**SECTION 96(A) OF THE TOWN AND COUNTRY PLANNING ACT (AS AMENDED)  
APPLICATION FOR A NON-MATERIAL AMENDMENT TO PLANNING PERMISSION: 16/1210/FUL  
UNIT 21 A, TEESSIDE PARK, STOCKTON-ON-TEES, TS177BW**

- Application Cover Letter dated 14 November 2023 (this letter);
- Application Forms and Certificates signed and dated 14 November 2023;
- Planning Permission Ref: 16/1210/FUL;
- Drawing Ref: 14199-104 Rev N – Proposed Elevations / GA; and
- Drawing Ref: 14199-104 Rev Q – Proposed Elevations / GA.

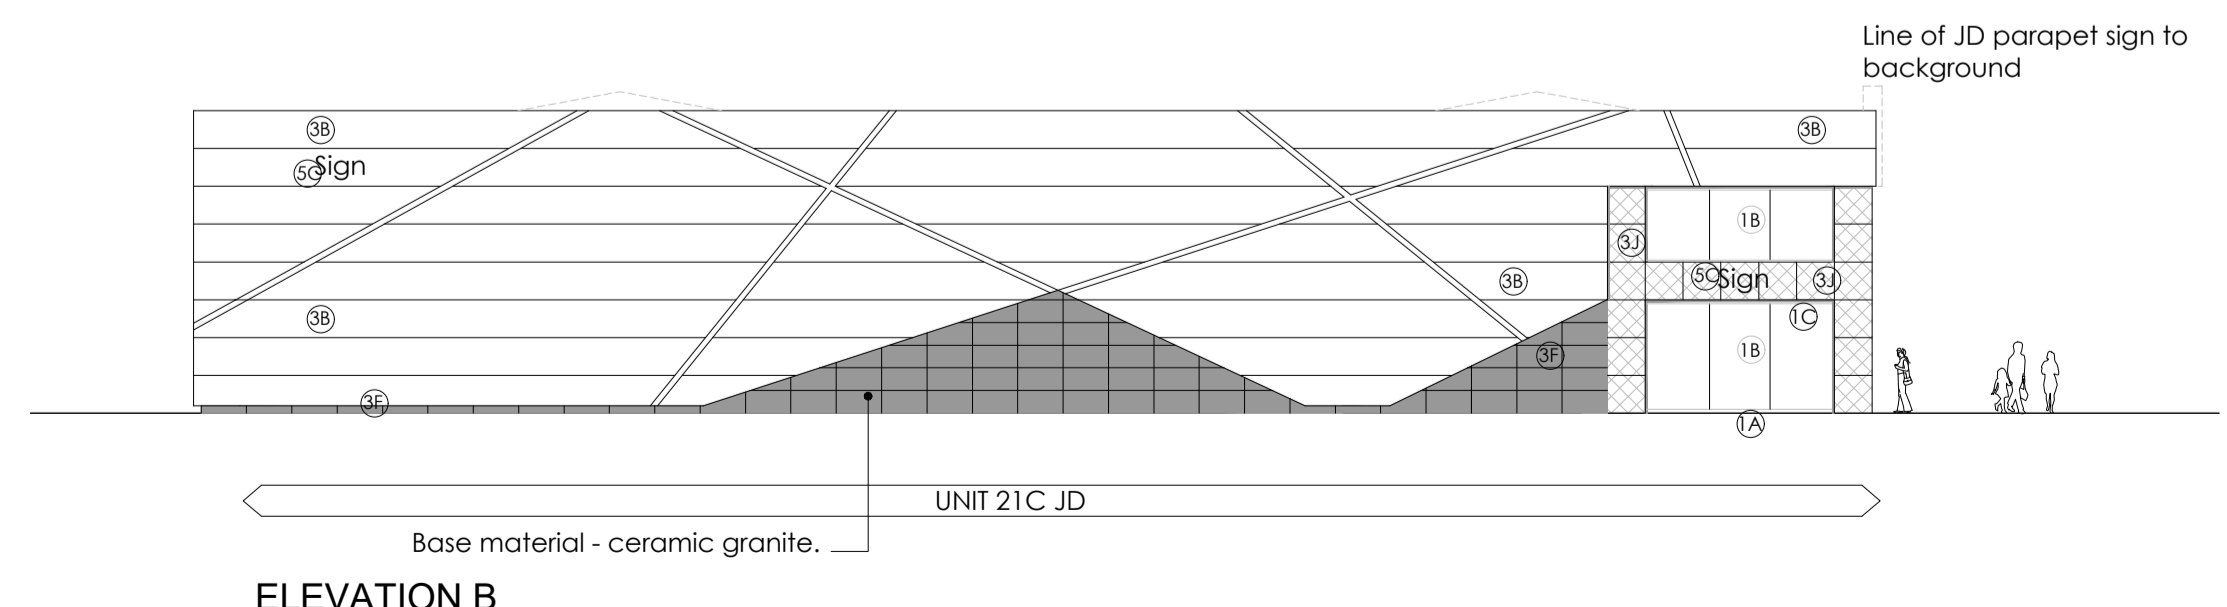
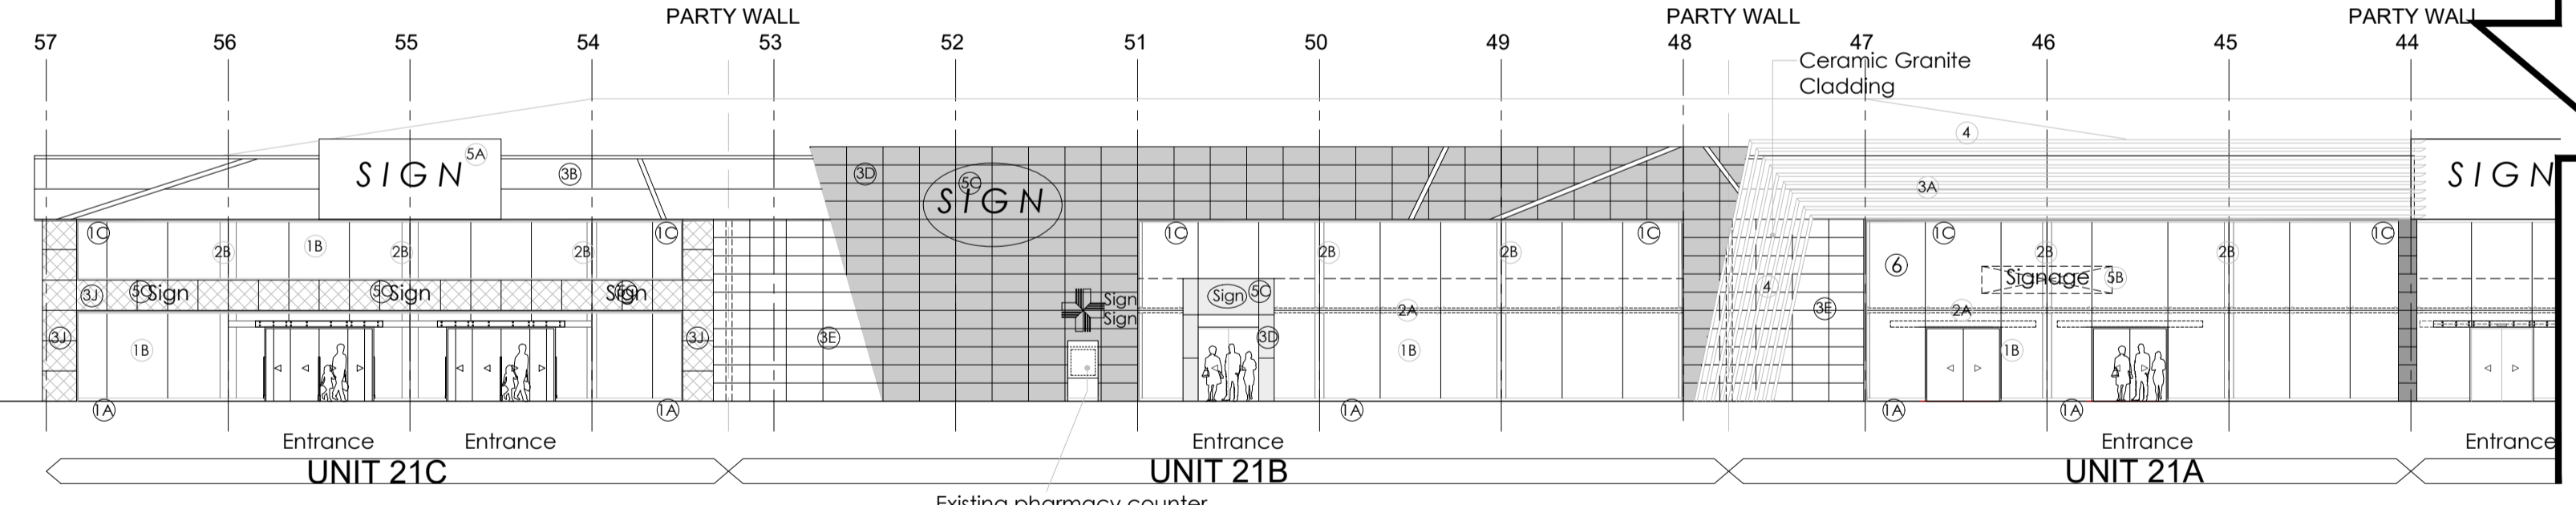
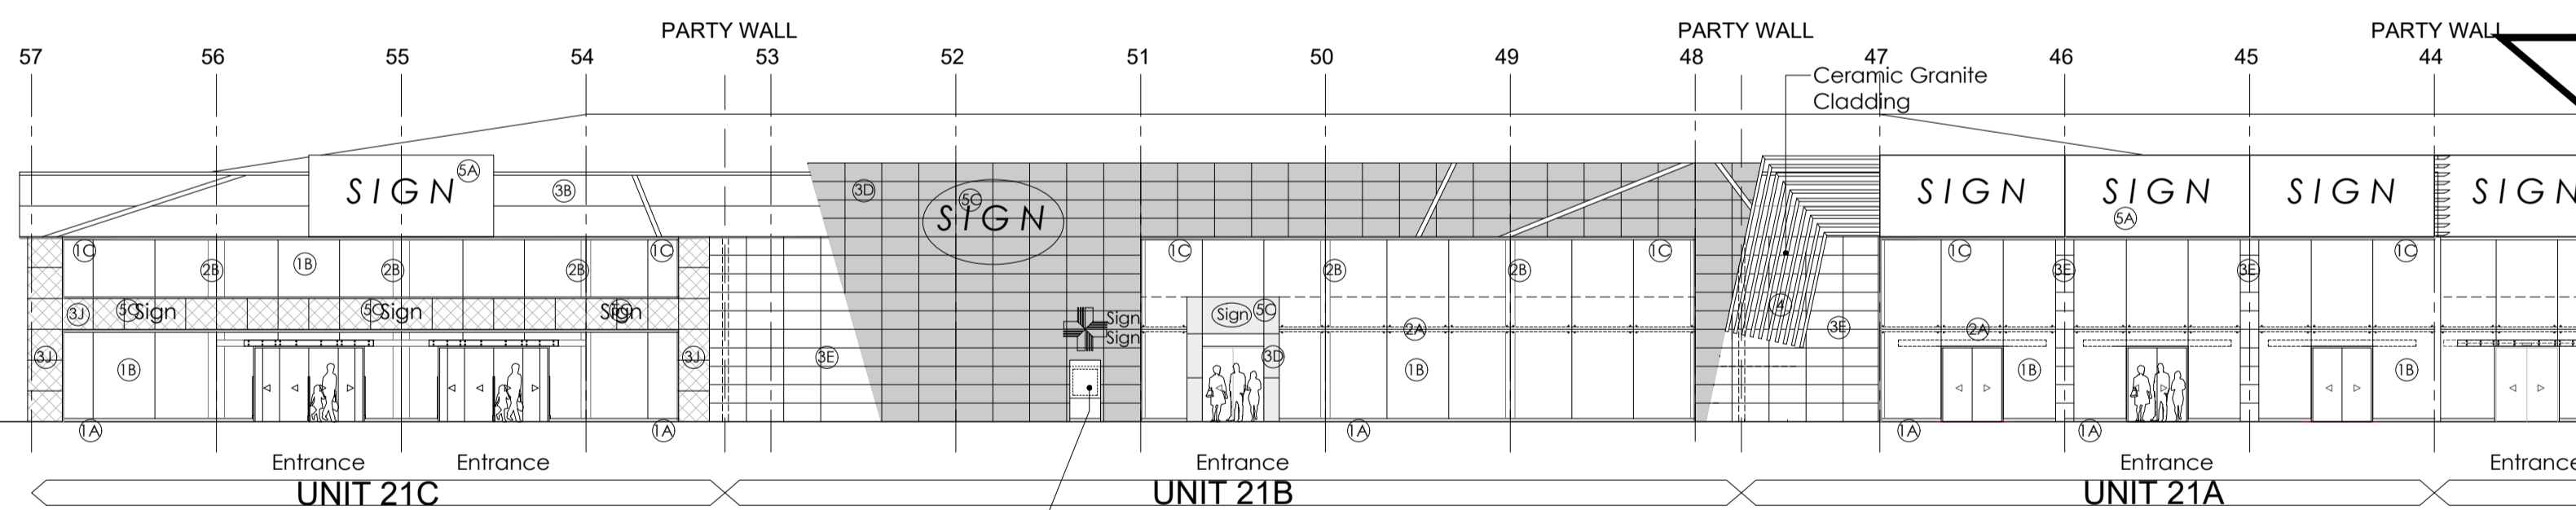
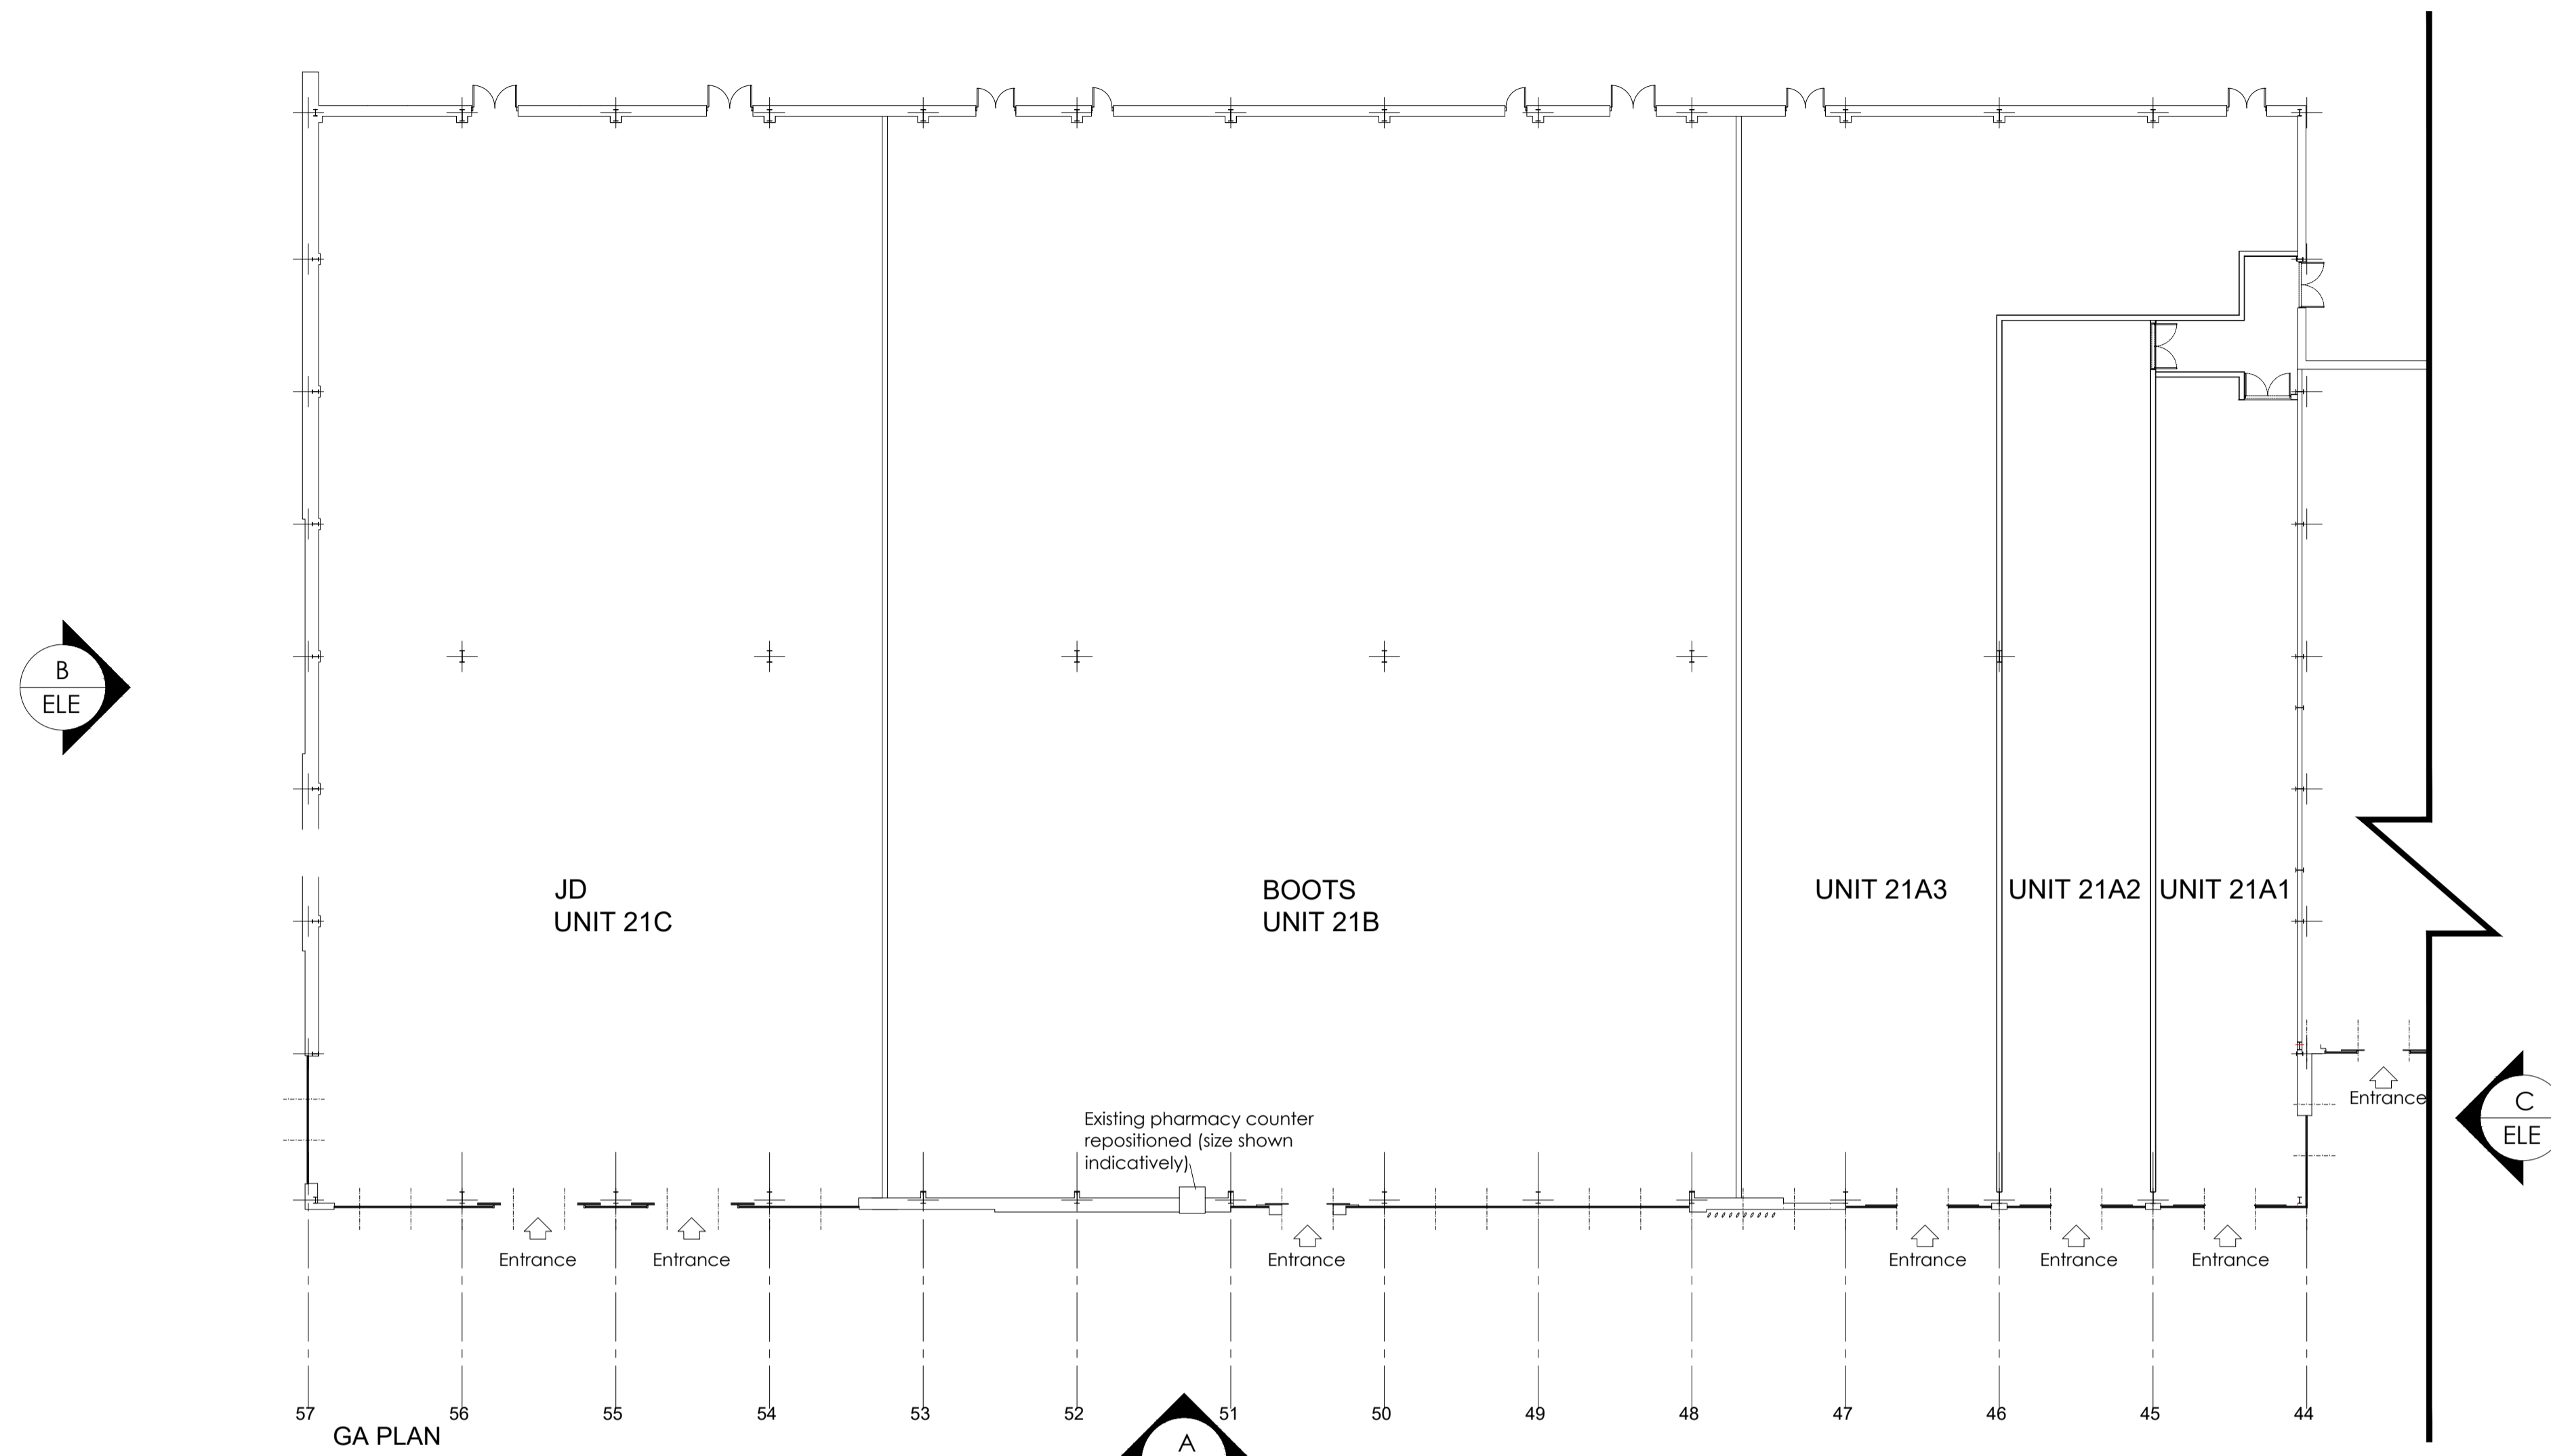
- Provision of a new entrance door for the proposed Unit 21 A1, to be integrated into structural glazing;
- Provision of 3 no. high level flex faced illuminated tenant signage zones for the proposed Units 21 A1, 21 A2 and 21 A3.
- Deletion of proposed secondary signage zone;
- Deletion of existing portal cladding columns, to be replaced with ceramic granite panels in black matt.

- Deletion of part of the proposed ceramic black matt granite panels, to be replaced with the provision of clear glazing panels with glazing support;
- Provision of brushed stainless steel plinth measuring 100mm.

In order to accommodate the proposed amendment, the application seeks the substitution of the previously approved Drawing Ref: 14199-104 Rev N (approved pursuant to Ref: 16/1210/NMC) with the updated Drawing Ref: 14199-104 Rev Q, which has been submitted as part of this application.
